**Re: Hannah Ridge at Feathergrass Filing No. 3 Final Plat- SF-17-012 - Review 2  
Project No. 60970-F3**

M.V.E., Inc. has prepared the following response to comments contained in your August 29, 2017 comment letter concerning the above named project. Revised submittal materials are enclosed as needed. Each comment is addressed below in the order contained in your comment letter.

**TRIBUTARY DRAINAGE IMPROVEMENTS**  
 FROM STA 1+00.00  
 TO STA 14+00  
 HANNAH RIDGE AT FEATHERGRASS NO. 3

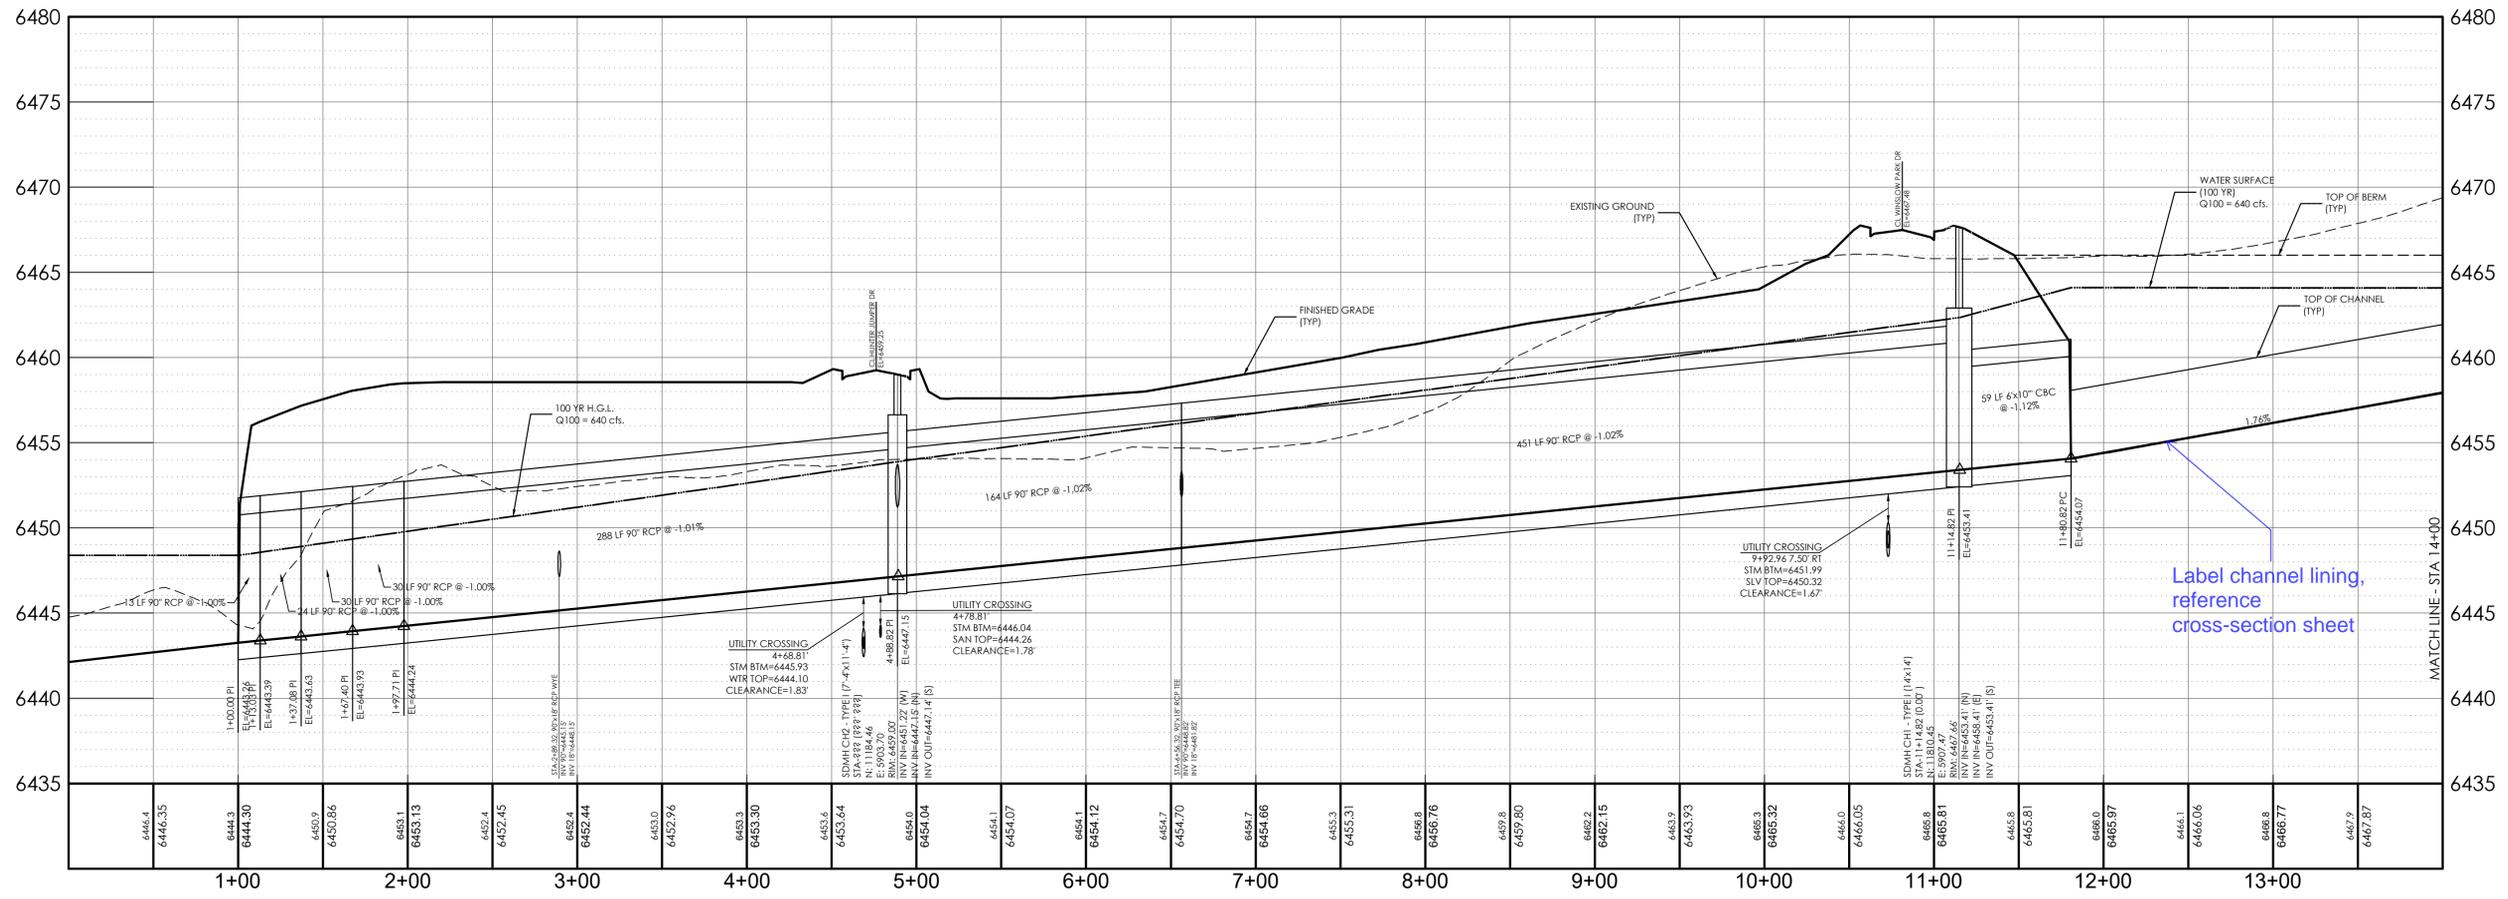
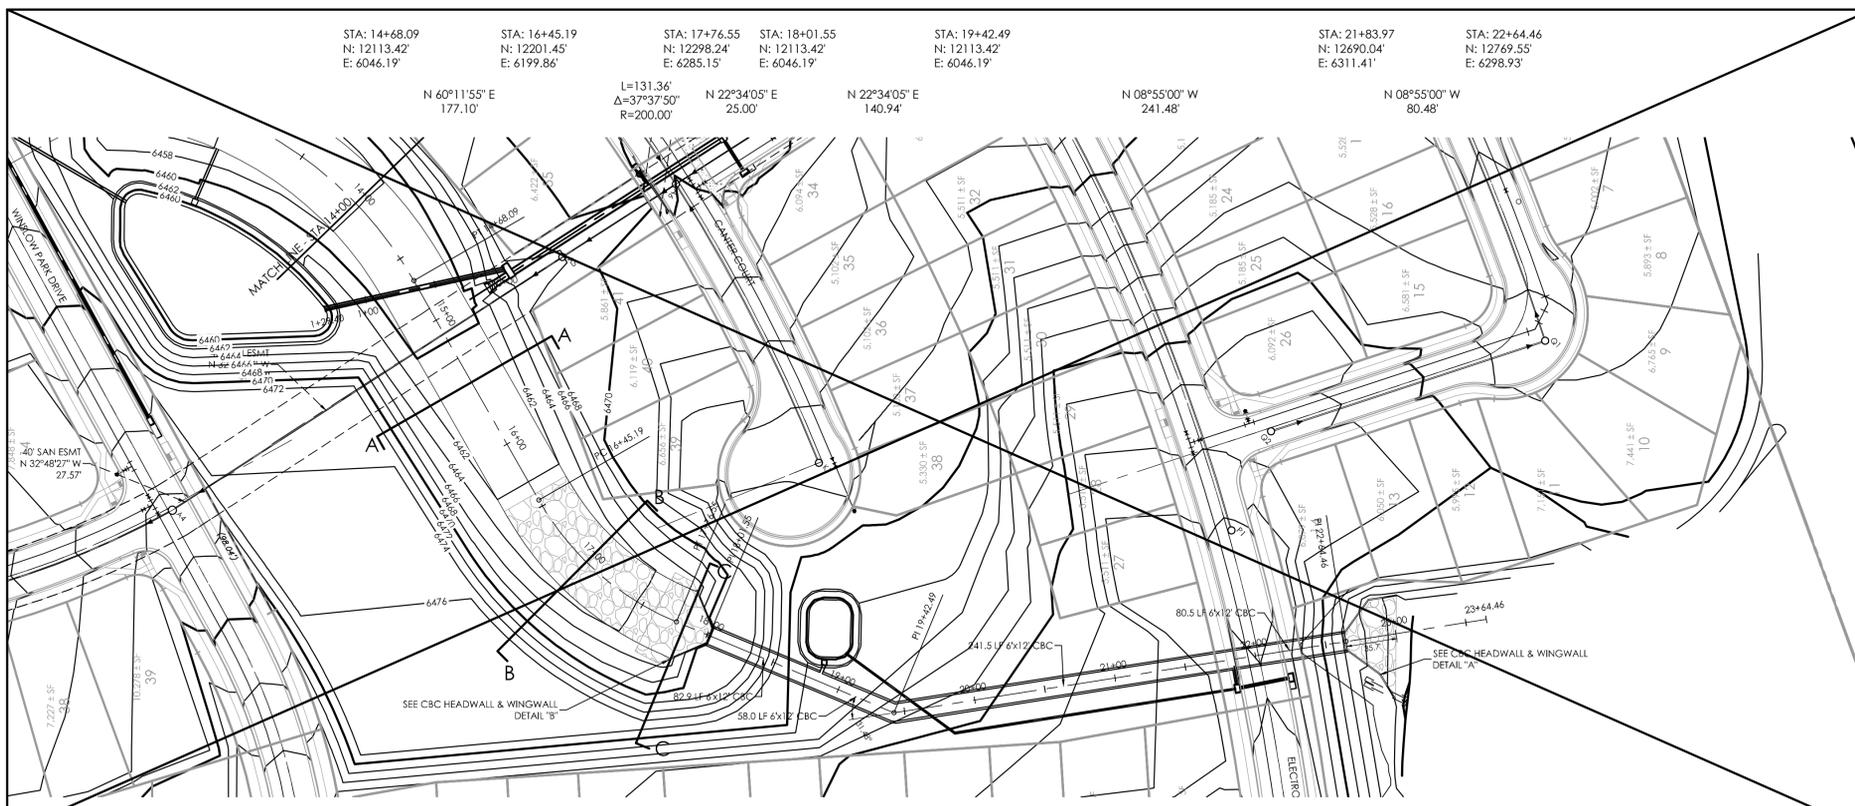
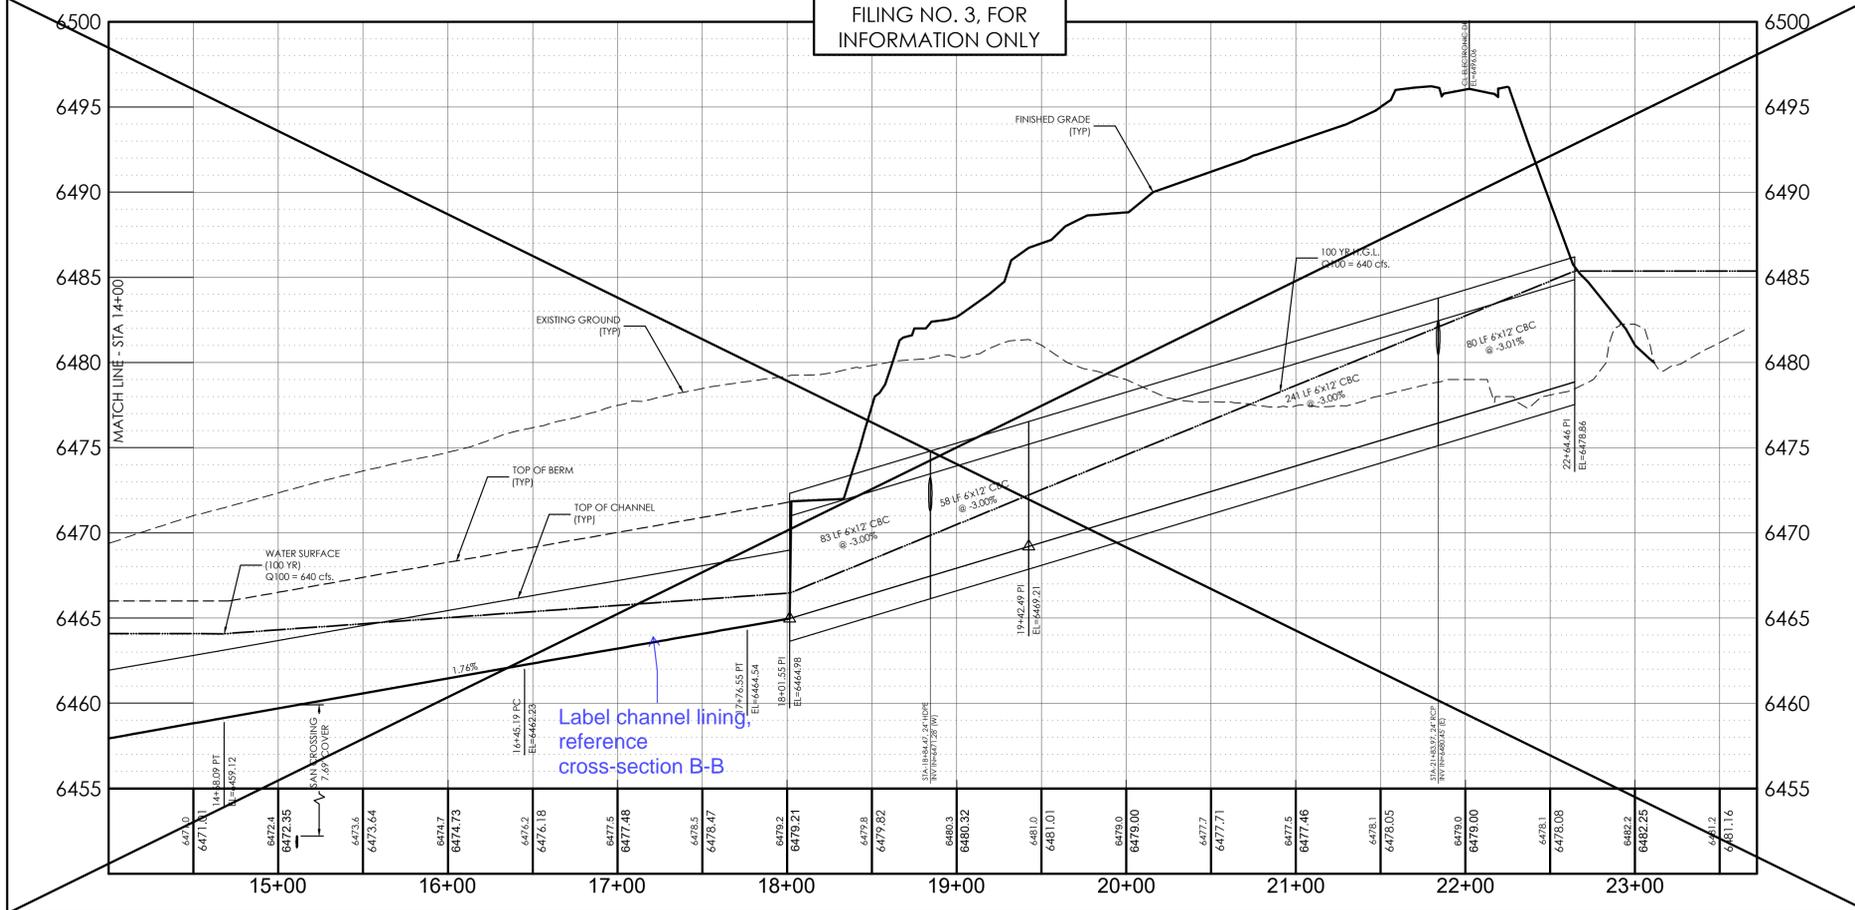
5. Discuss maintenance access provisions for storm sewers and the channel to the north. Show access trails on the plans. **Unresolved; see redlines. Response: access to facilities is discussed in report and shown on the plans.**

Short-Term Traffic Signal Warrant Constitution/Hannah Ridge Following Filing 3

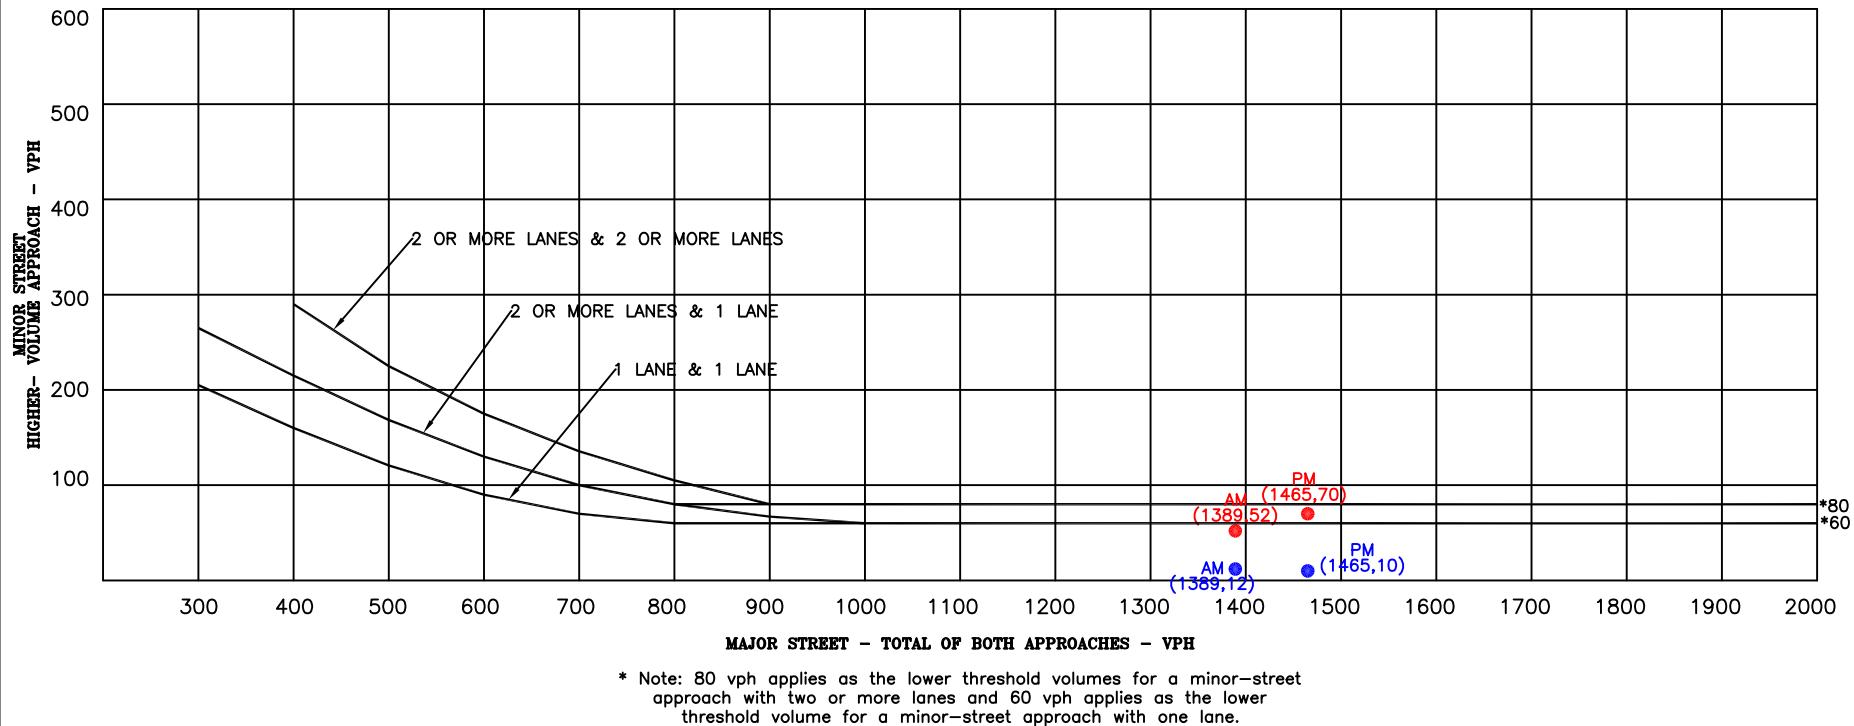
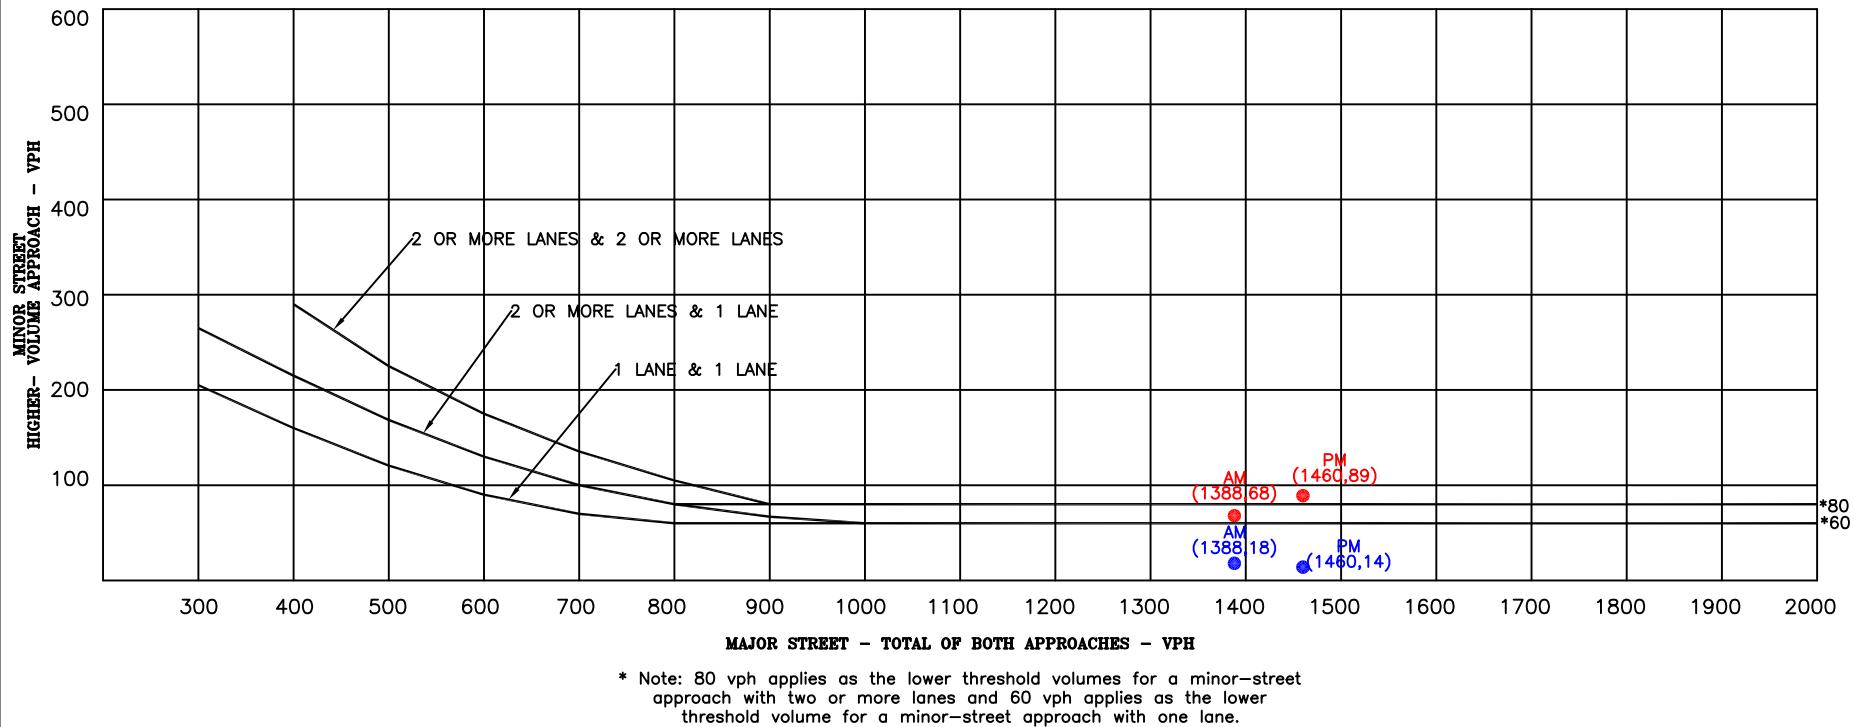
1. The Hannah Ridge Dr./Constitution signal escrow discussion on page 7 (and Table 3) needs to be revised. If there is no escrow from other developments in place, the Hannah Ridge development needs to fund the signal with adequate escrow obtained from this and future filings, with the percentage contribution much higher than proposed. **Partially resolved; the contributions currently allocated to existing traffic needs to be re-allocated to future development only in order to reach the necessary funding (see redlines). Response: The report is revised to include two escrow scenarios as discussed in recent meeting – one including existing background traffic and another which excludes the background traffic.**
